# MOLLETT'S FARM

## Comment on Responses to ExA's Written Questions (D3)

This document contains our Deadline 3 comments to the responses received to the Examining Authority's Written Questions, for the Sizewell C development application.

**PLAN 11(b)
TWO VILLAGE BYPASS
SITE PLAN**

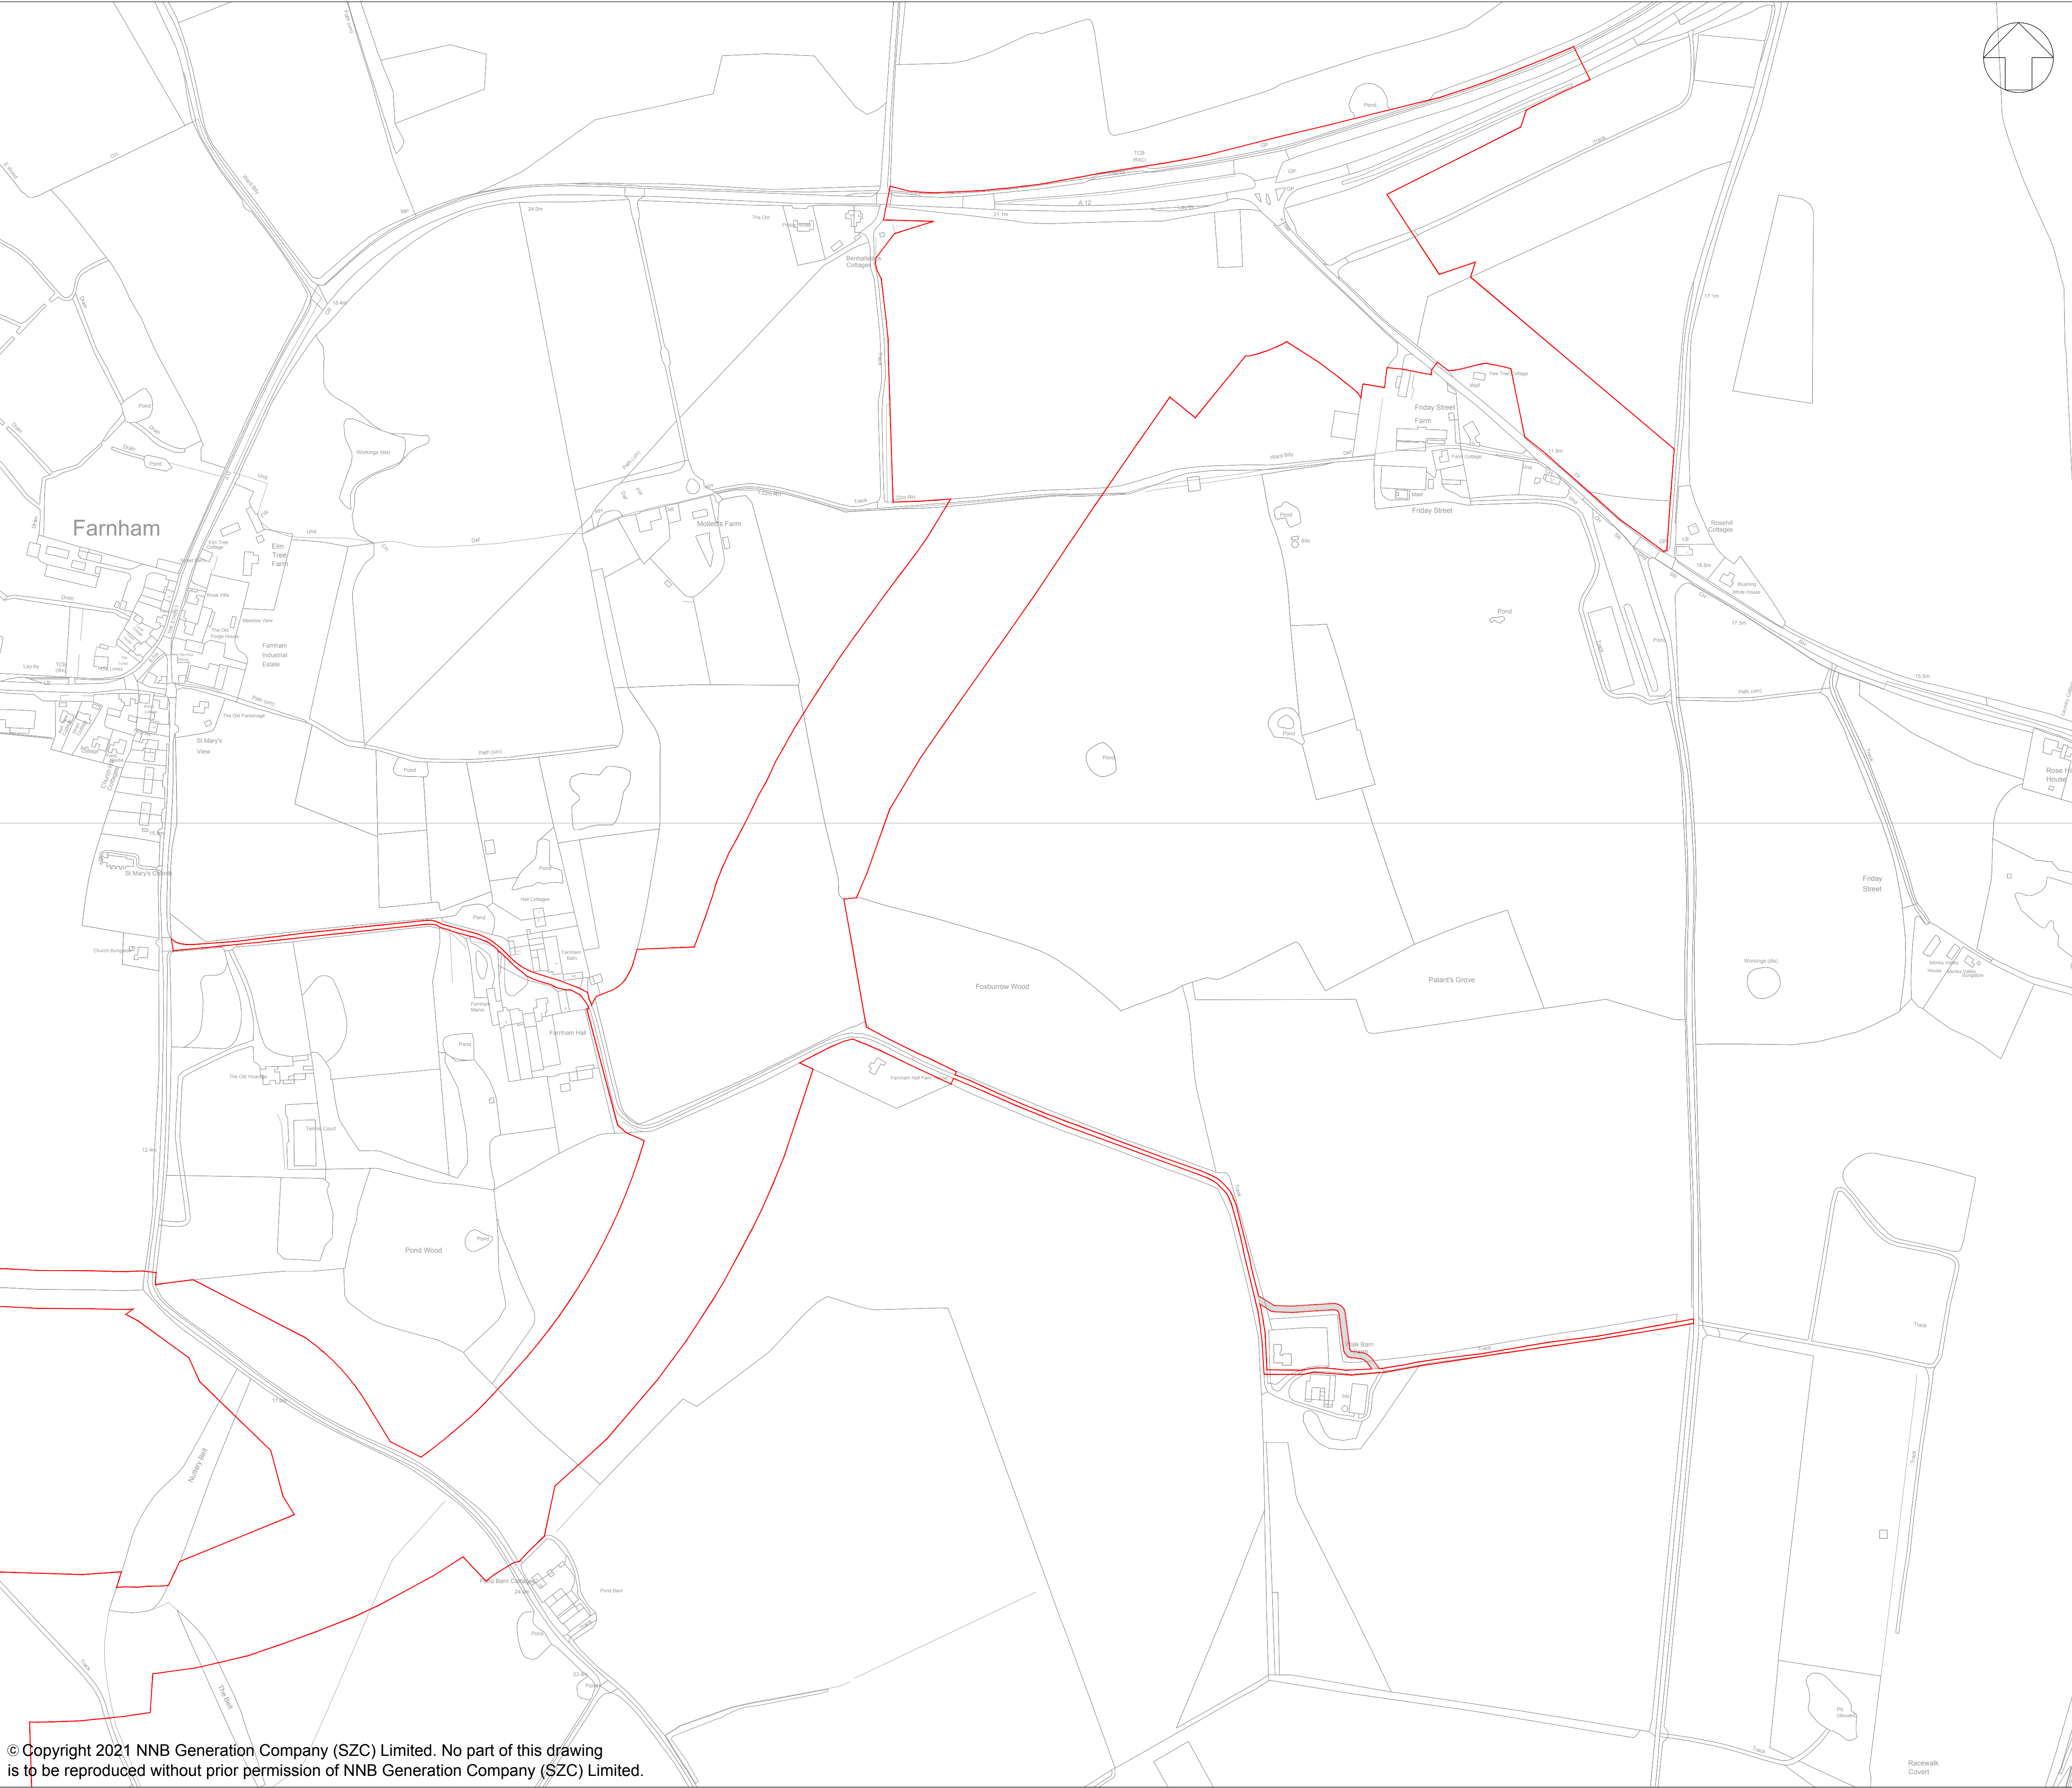
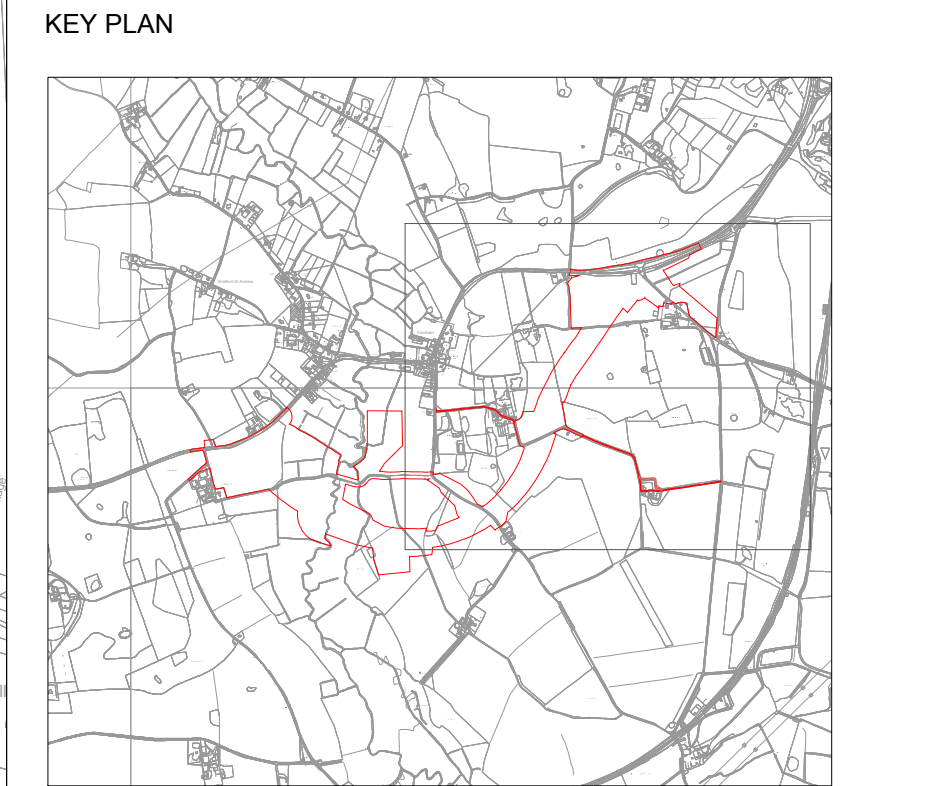
The applicant states that *"The buildings within Mollett's Farm are located approximately 150m from the site boundary"* as if this answers the ExA's question. It does not. EDF is failing to recognise that our business is not just the buildings forming our self-catering accommodation offering or our farmhouse, but the entire farm environment. Guests currently relax in outdoor garden spaces, enjoy nature walks, pitch tents and attend events in parts of the farm that are considerably closer to the site 'red line' boundary – as close as 15m in fact – as clearly seen by the ExA during the recent Accompanied Site Inspection (ASI). The future enjoyment and use of these areas will be dramatically affected by TVB construction and operation.

As to the visual effects, it is nonsense to suggest that the impact is not significant when it is obviously very significant. There is a huge difference between looking out over fields as opposed to looking out over a road under construction and then a busy road for at least 10 years during construction of Sizewell C (after all, that is why they say they need to build it). We are hoping that the ASI enabled the ExA to recognise how ridiculous EDF's assertions are.

The usability and safety of our existing A12 access to and from our business and home is likely to be severely compromised during construction of the TVB. However, there is still no response on this issue. For example, how should we and our guests get in and out safely, especially when towing a caravan or large agricultural equipment?

Our guests’ ability to access to local amenities (the shops and the café restaurant at Friday Street are within walking distance) is a key selling point for an out-of-town businesses such as ours. This will be completely severed. No acknowledgement of this has been made. Similarly, no provision has been made to mitigate or compensate for its loss.

We need proper protection / mitigation involving bunding, noise attenuation fencing and screening. Not just a minor cutting that does not hide the traffic and a few plants that will take 15 years to become established and potentially exacerbate the noise generated by the TVB.

The applicant's claim that *“culverts beneath the bypass will enable the continued flow of the existing drainage network”* also neatly demonstrate a complete lack of understanding of the specifics of the situation and their lack of engagement with us. Their documentation shows that the TVB will be in 1.9 m deep cutting at the point that it crosses our existing drainage route, putting the suggested culvert at least 2 m below both the ground-level inlet on the Mollett's Farm side and the ground-level outlet on the Friday Street side. Once our water has dropped into their cutting, it will not be going anywhere but downhill – along the route of the TVB.
